From: Martyn White on behalf of Conservation Officer
Sent: 29 August 2025 16:42
To: Jessica Riches
Subject: F/14/24/RES

F/14/24/RES

Land at Ford Airfield Ford

Approval of reserved matters (layout, scale, appearance and landscaping) following outline consent F/4/20/OUT for the infrastructure reserved matters including the provision of a primary spine road and associated secondary road junctions, pavement, footpaths, cycle infrastructure and bus stops; site wide drainage infrastructure including foul pumping stations, foul sewer infrastructure, SUDS basins, SUDS swales, surface water infrastructure; acoustic fencing; public open space including landscape details, play areas, footpaths & associated works

Status:	For Planning	GP	TF
Project Number:	180641	Scale @ A1:	1:500
Drawing Number:	TOR-RMIN-XX-DR-L-P-007	Date:	06/2024
		Revision:	B

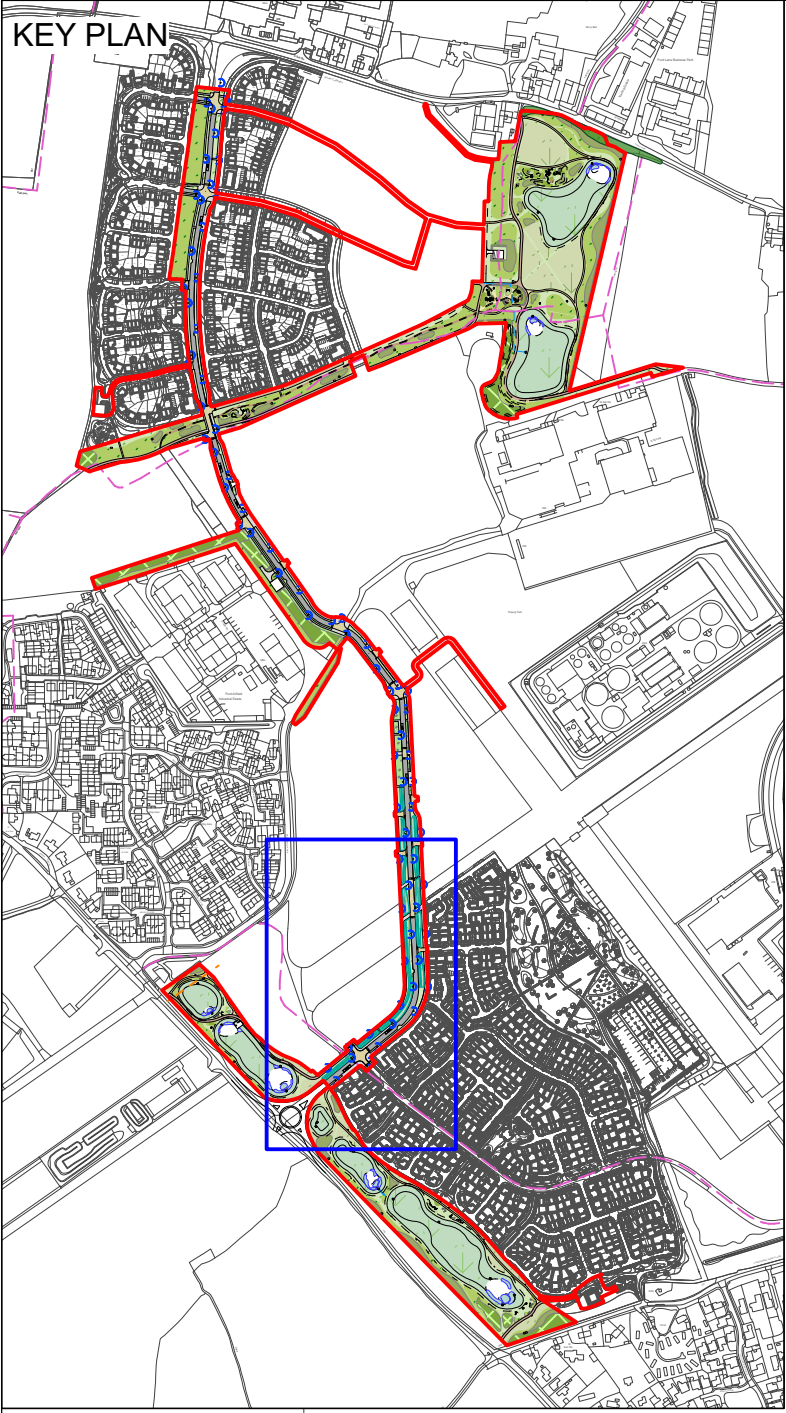
The amendments described in the heritage statement regarding the runway and shown on the following plans (TOR-RMIN-XX-DR-L-P-007 Rev F/ TOR-RMIN-XX-DR-L-P-027 Rev B) seem to be an improvement and therefore acceptable.
